Craigweil House and its Environs

AW-71-18-HH – CHECAA Objection Reinforcement – 16-7-2018

OBJECTION: to AW/71/18/HH – 36 Kingsway – proposed development likely to harm the Craigweil House Area of Special Character and Craigweil House Conservation Area and its setting

Proposed Ground Floor Plan

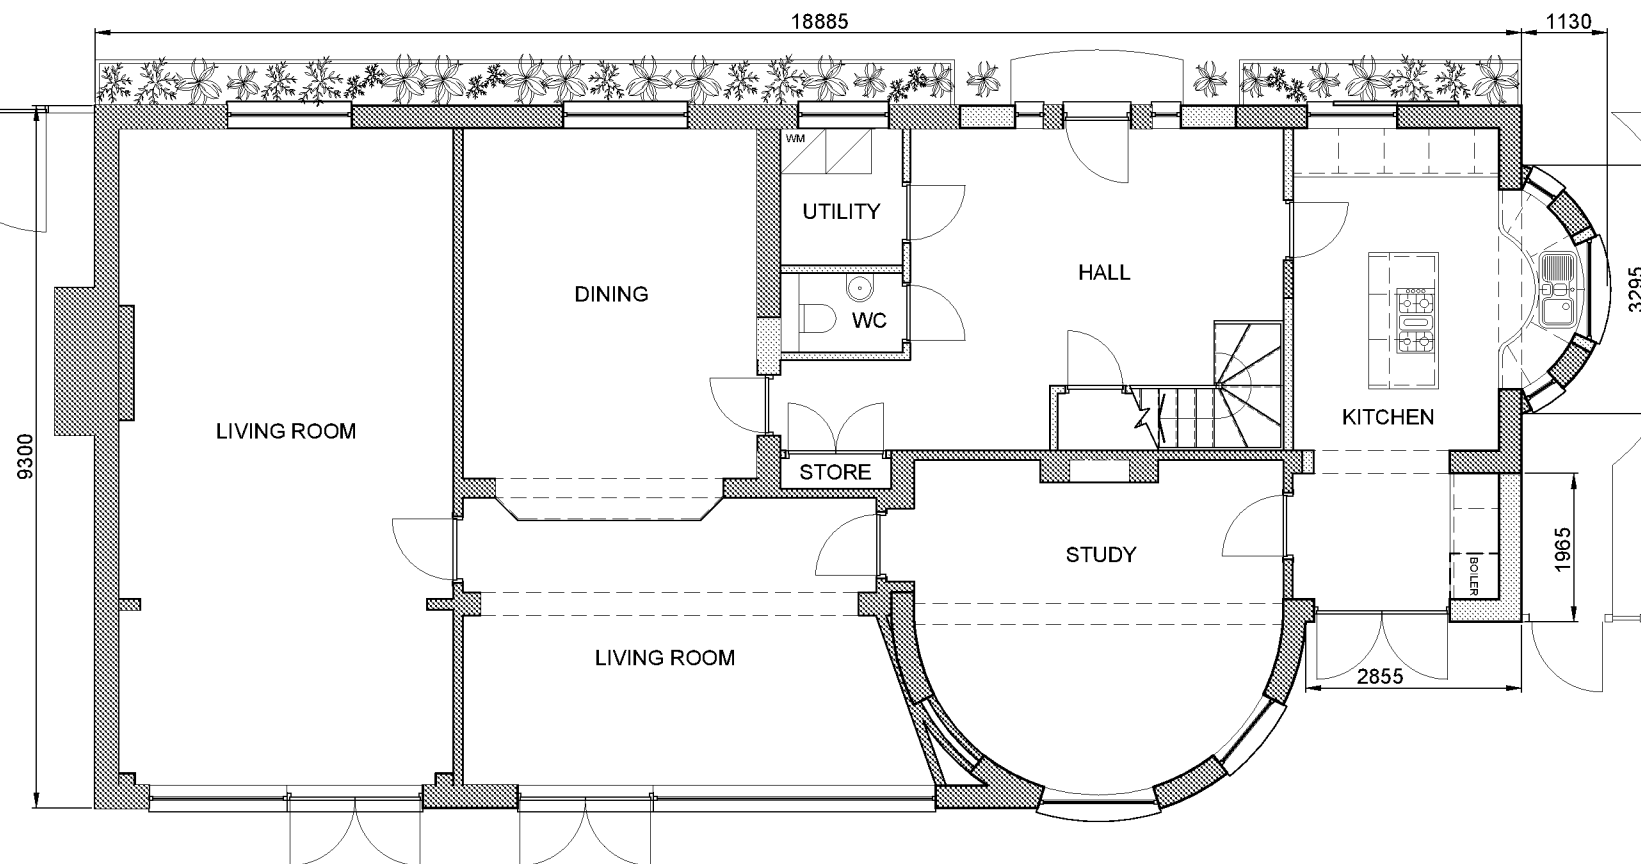
NOR has the issue of the gates themselves even been mention for it has to be understood that to drive into or out of Queenslawn will necessitate gates OPENING OUTWARDS and they will completely block off the public verge which they do not own. And they are likely to be left open from time to time - to the danger of others.

Residents and pedestrians generally will be obliged to walk into the road for there are no footpaths, as has already been mentioned. If the gates are conditioned to open INWARDS then no car can be driven in or out and it would be a travesty if Arun was to be a Party to approving open gates which led to an incident where a pedestrian, forced into the roadway, was to be injured or killed. Arun could well have a liability.

Drawing
Arboricultural Impact Assessment,
Arboricultural Method Statement

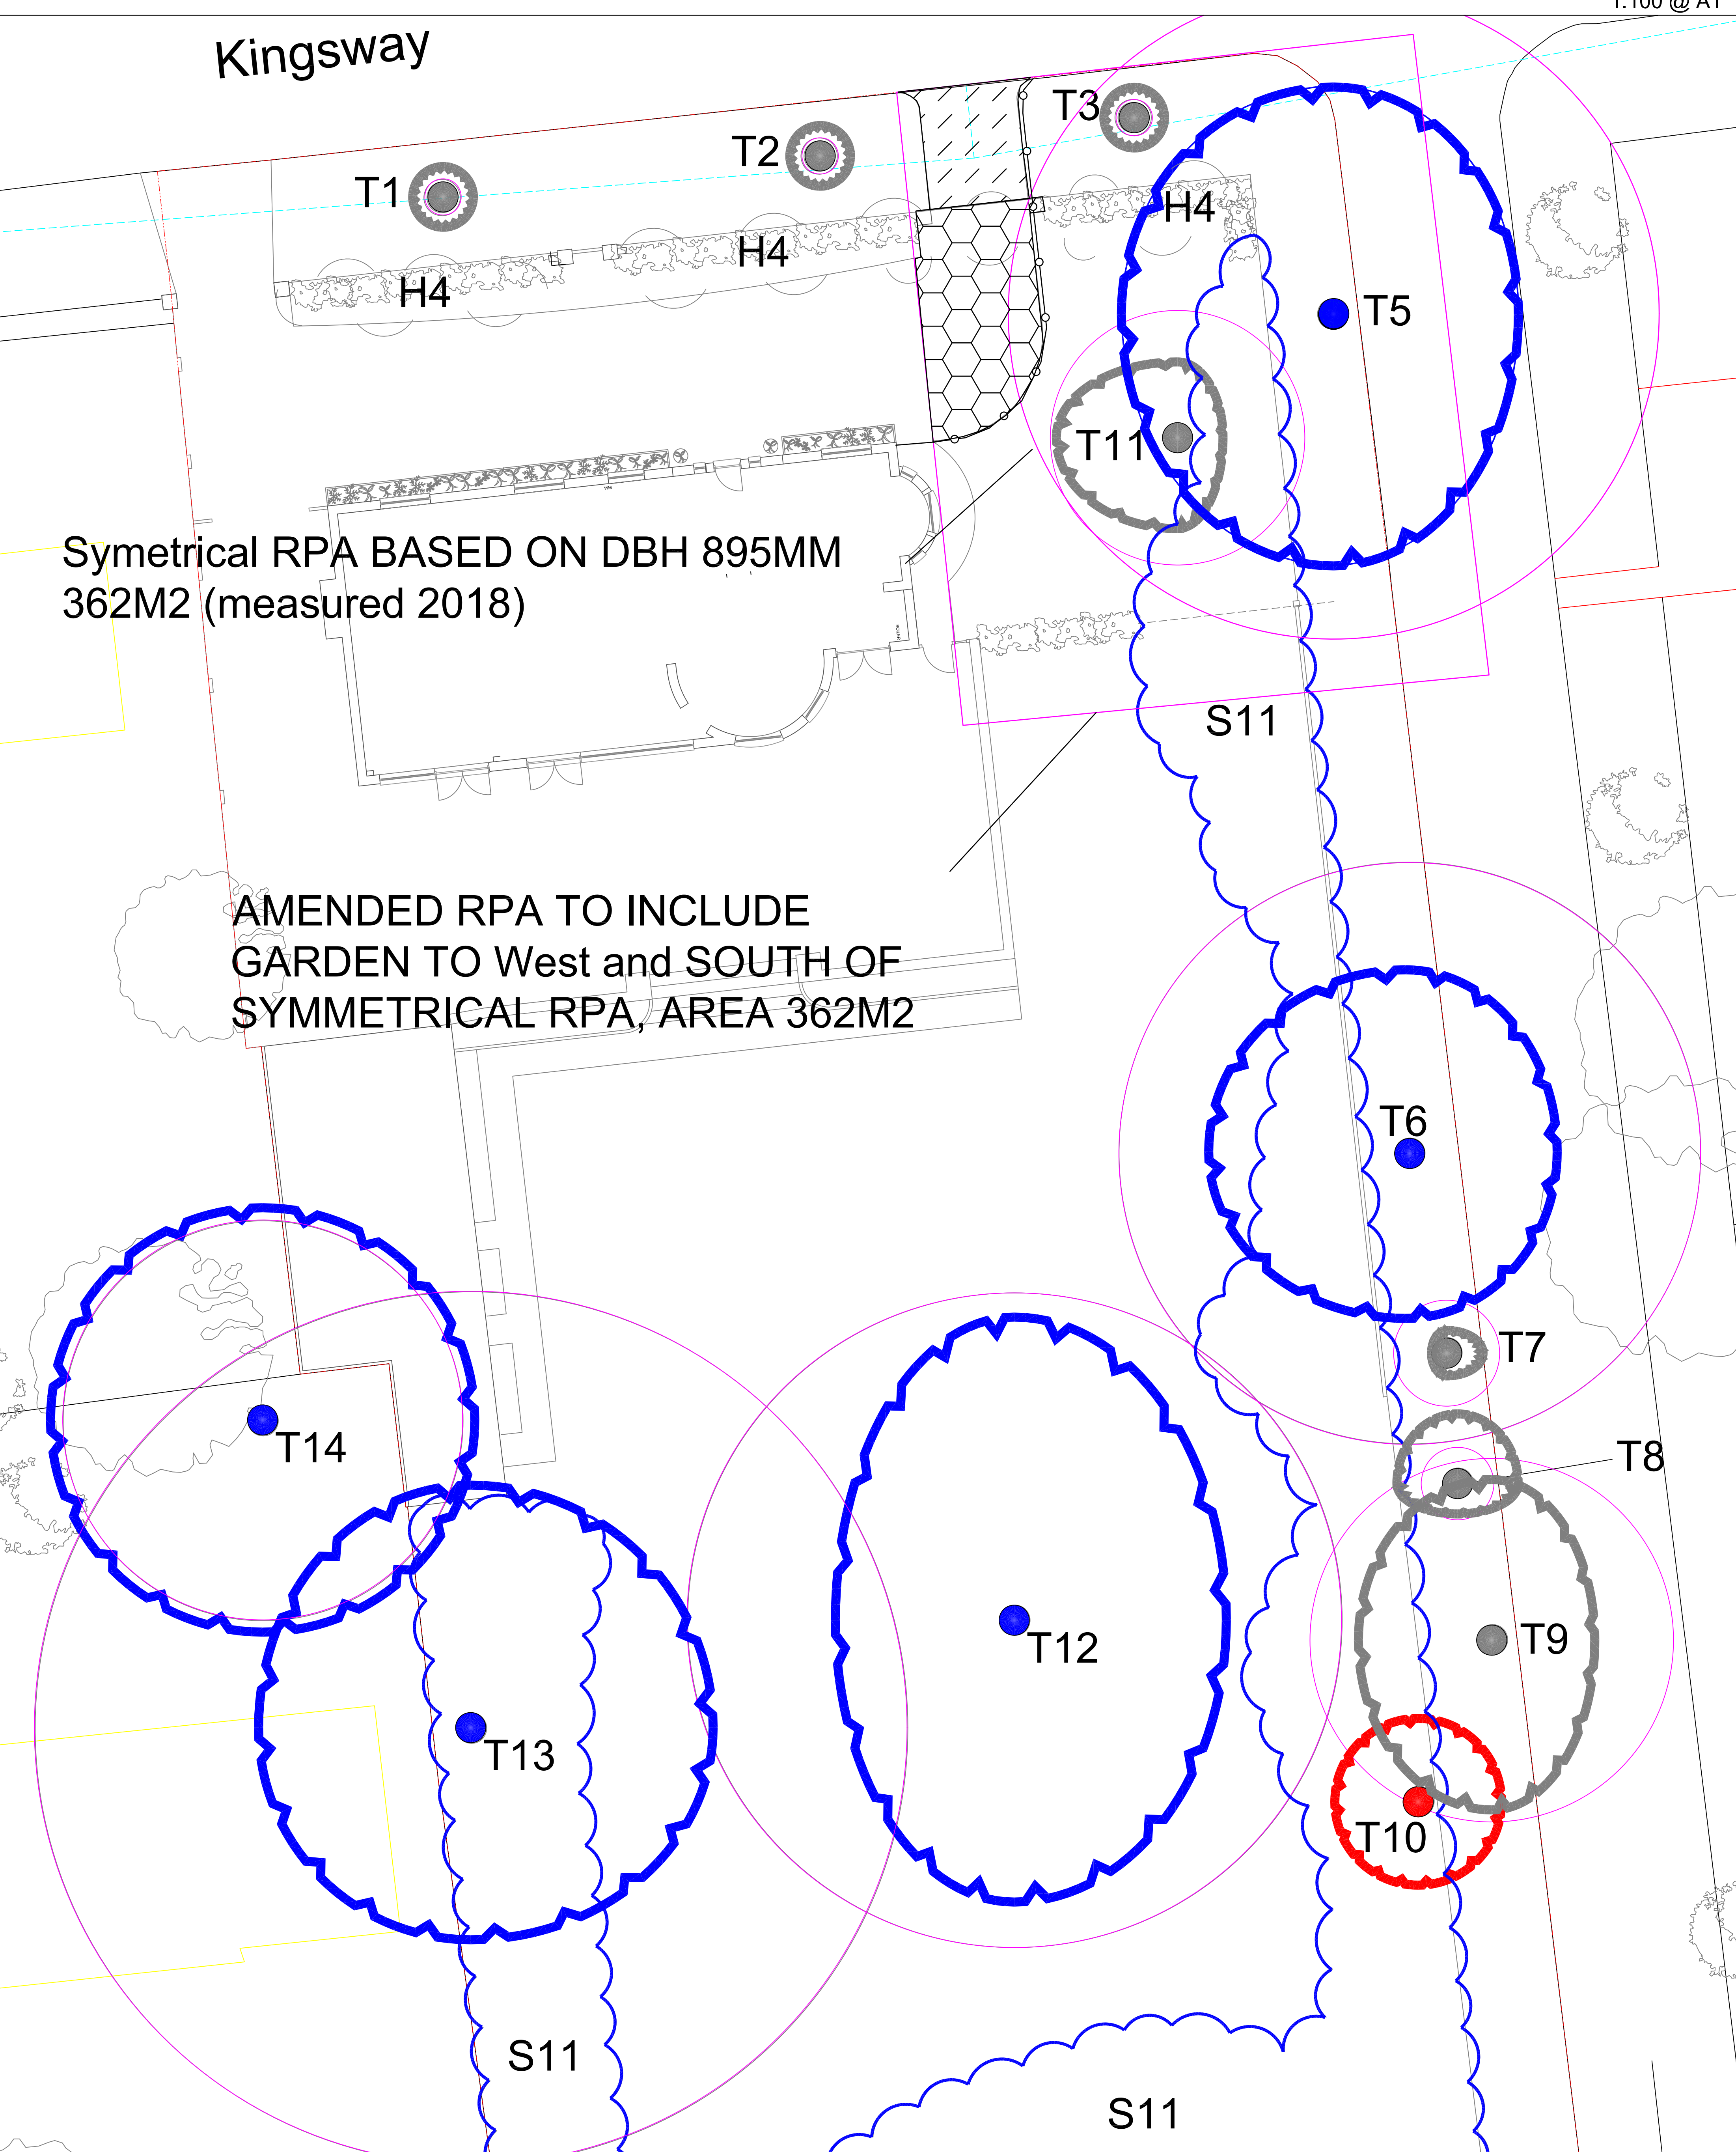
The applicant has submitted no details of the building of a boundary wall and gate posts – nor have the LPA, again ignoring our quite proper and professional request – sought any details of the gate posts which BOTH WILL BE WITHIN THE Root Protection Area (RPA) where work of this type will harm or kill tree T5. The posts will have to be 18 inches square and have footings dug out to a depth of at least 2 feet and 3 feet square. That will decimate ALL the root system in that area but it has not been mentioned. THEN the foundation will be HIGHLY TOXIC CONCRETE, which will creep and kill roots.
